**Maryvale Solar Farm (SSD-8777)  
Request for Additional Information**

I refer to the application and Environmental Impact Statement for the Maryvale Solar Farm (SSD-8777). The Department is requesting that you provide additional information.

APPENDIX 6: ROAD UPGRADES AND SITE ACCESS

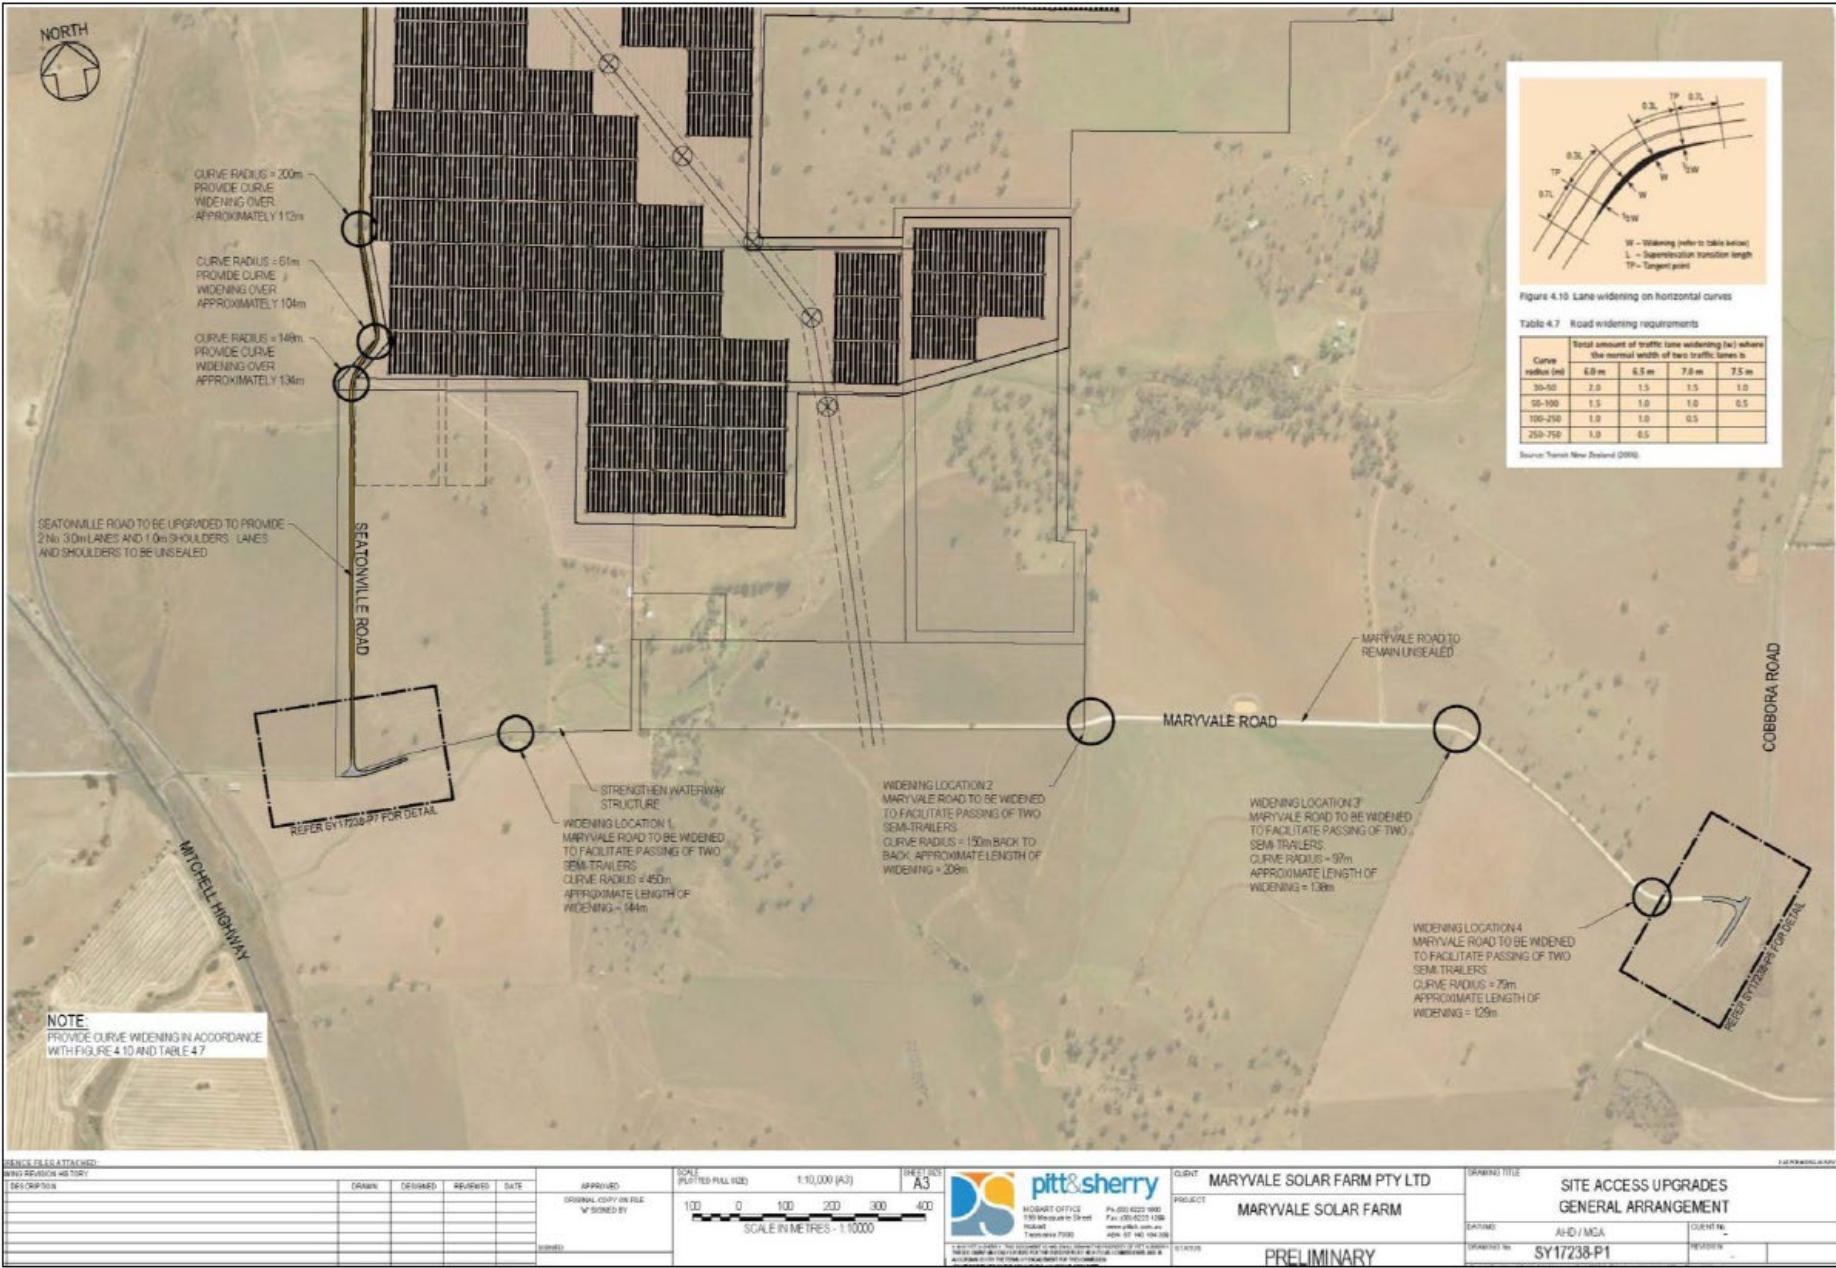
- Provide high quality version of the attached figure from Appendix C of the TIA (Concept Road Designs) for inclusion in the Conditions of Consent. Enlarge the text describing the Maryvale Road upgrades so that they are legible at A4 printing size;
- Confirm if there are any additional existing waterway crossings on Seatonville Road immediately north of the transmission line easement and on Maryvale Road. Detail whether their condition has been assessed and if these need to be strengthened;
- Amend the Constraints map:
  - Change colour of access point marker to a more obvious colour
  - Change colour of haulage route to a more obvious colour
  - Either reduce the transparency of the solar array OR change to a hashed layer to ensure layer consistency; and
- Confirm that any additional water can be sourced from an appropriately authorised and reliable supply
